REQUEST

Current Zoning: CG (General Commercial) & I-1(CD) (Light Industrial, Conditional)
Proposed Zoning: MUDD (CD) (Mixed Use Development District, Conditional)

SUMMARY OF PETITION

STAFF RECOMMENDATION

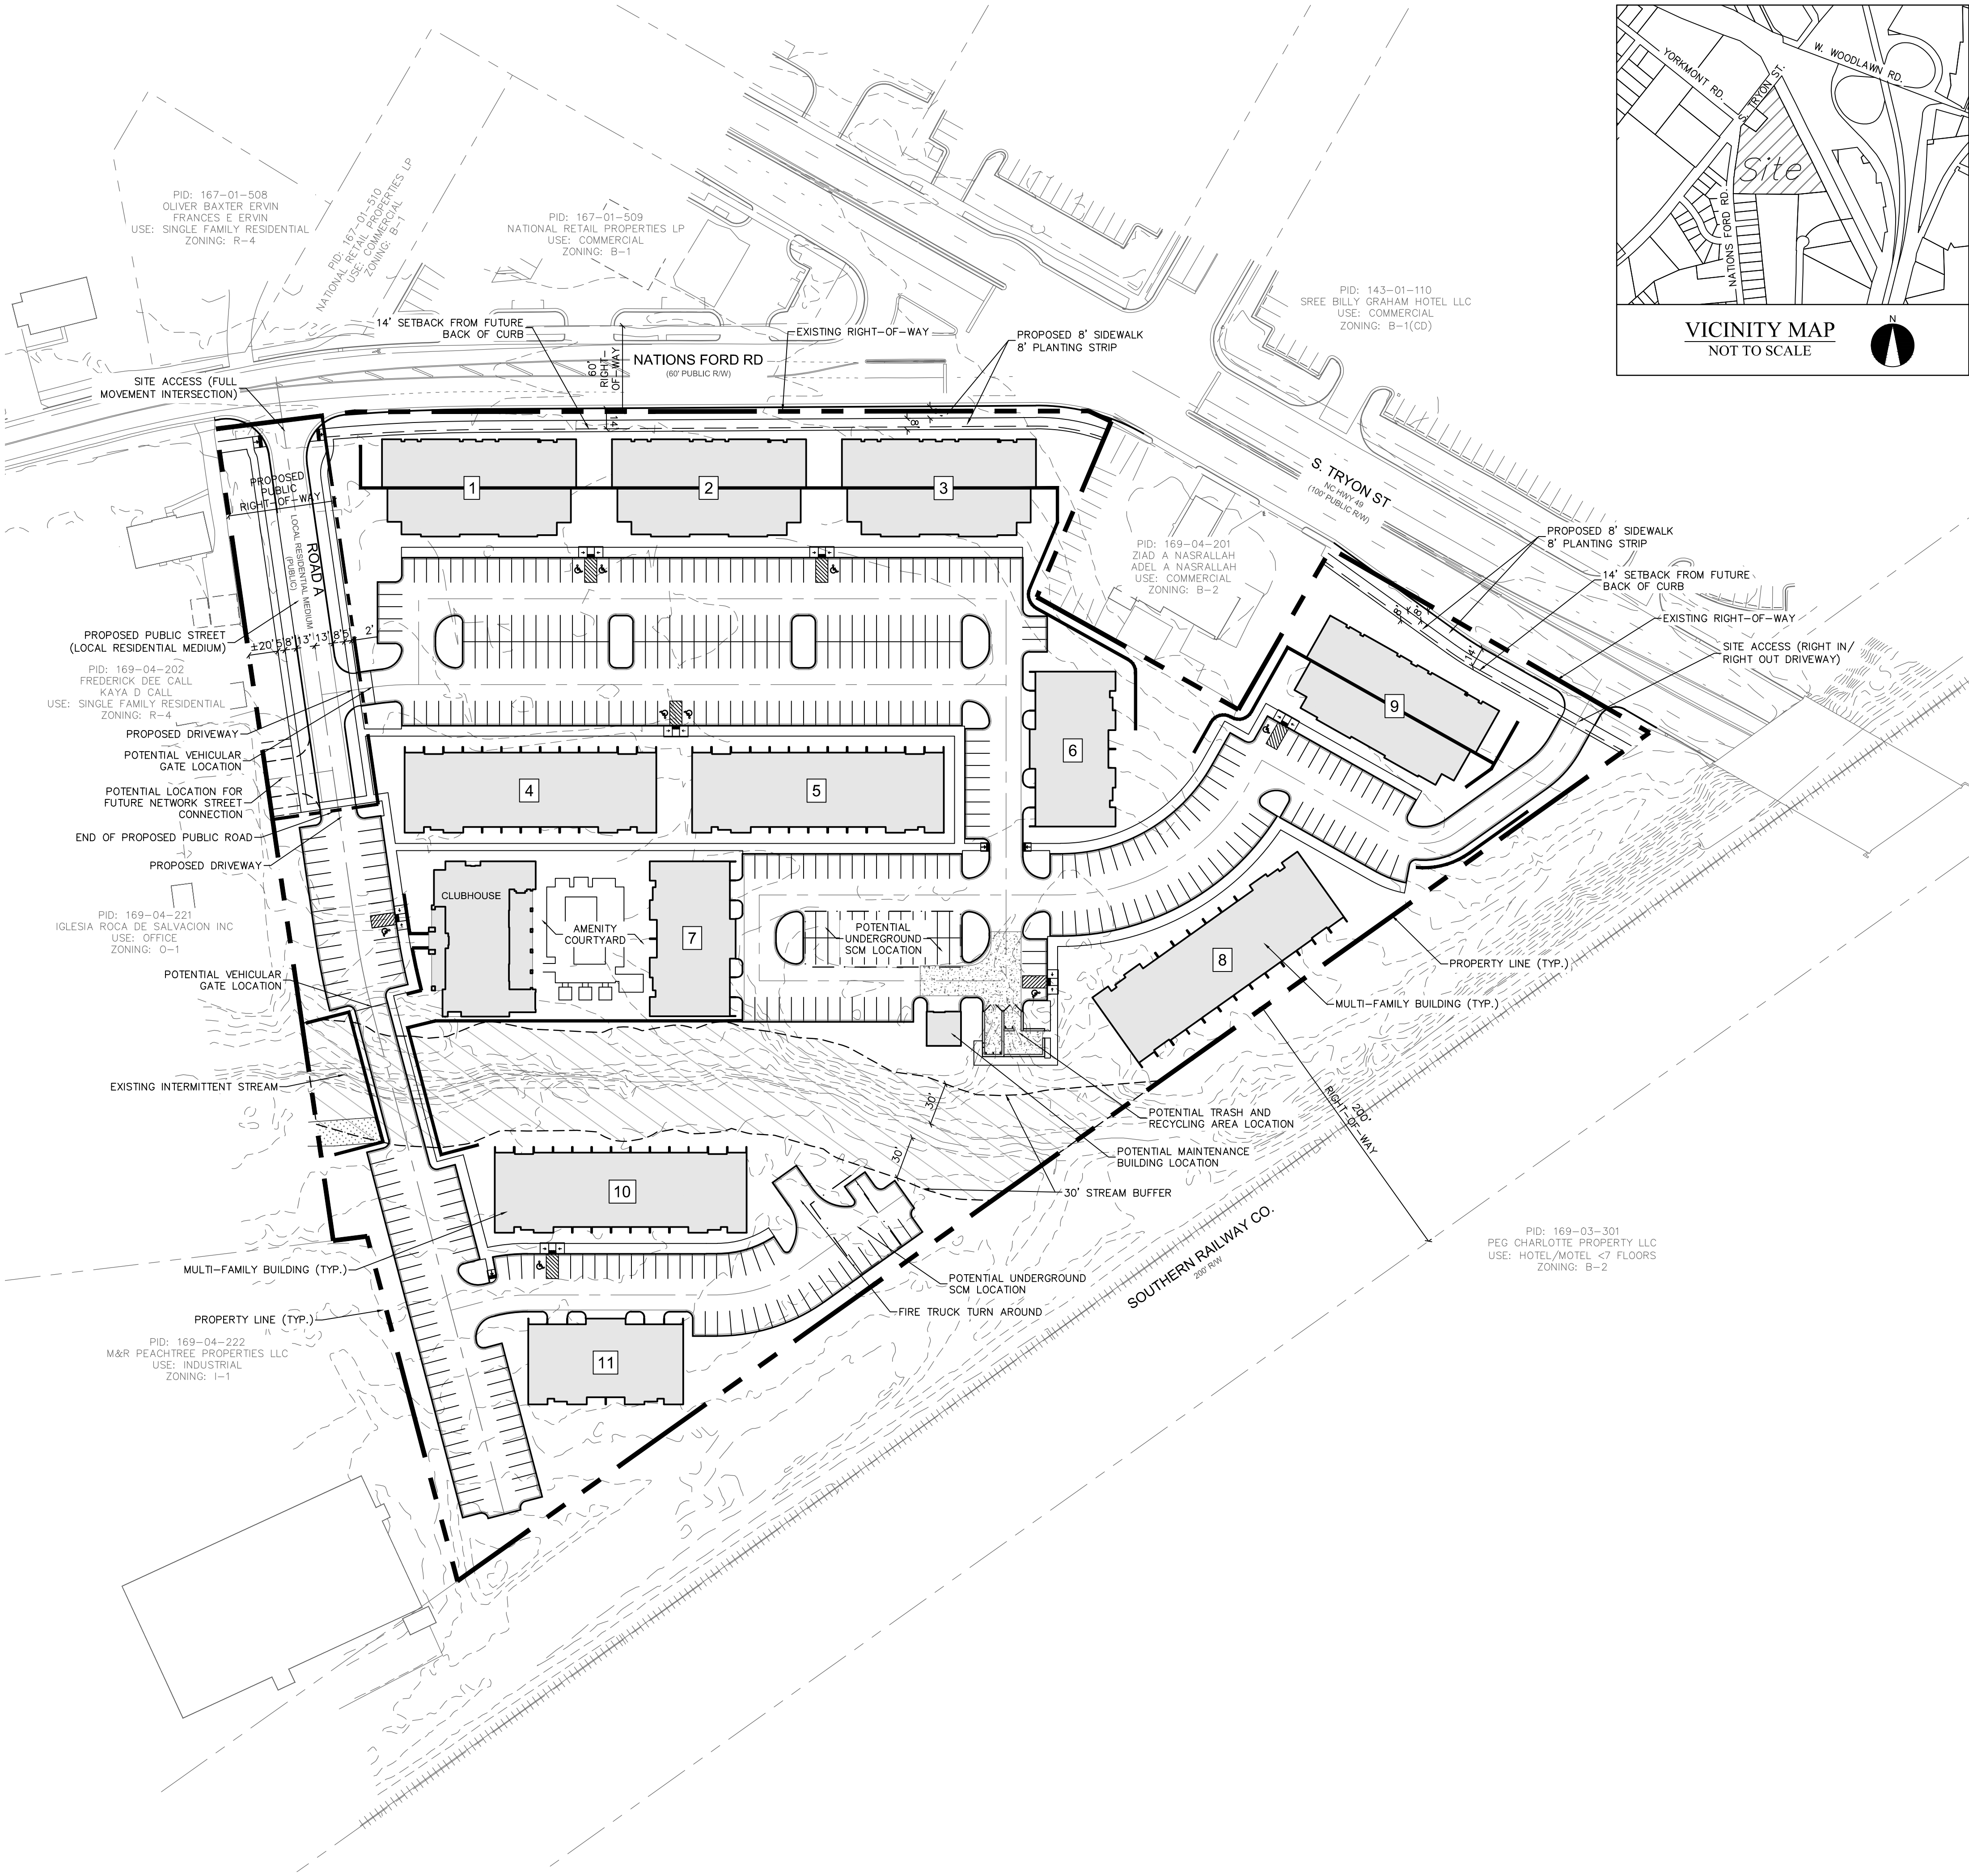
1. The site is recommended for Commercial place type. The proposed ~~20,000~~ 5,000-square foot of non-residential uses is not sufficient to meet the intent of the Commercial place type. **Staff requests a commitment on the timing of construction for the 20,000 SF of commercial, and a more direct commitment of ground floor commercial uses in buildings facing S. Tryon St.**

10. **Create a second sheet for the conditional notes and clarify the note order/numbering.**
-
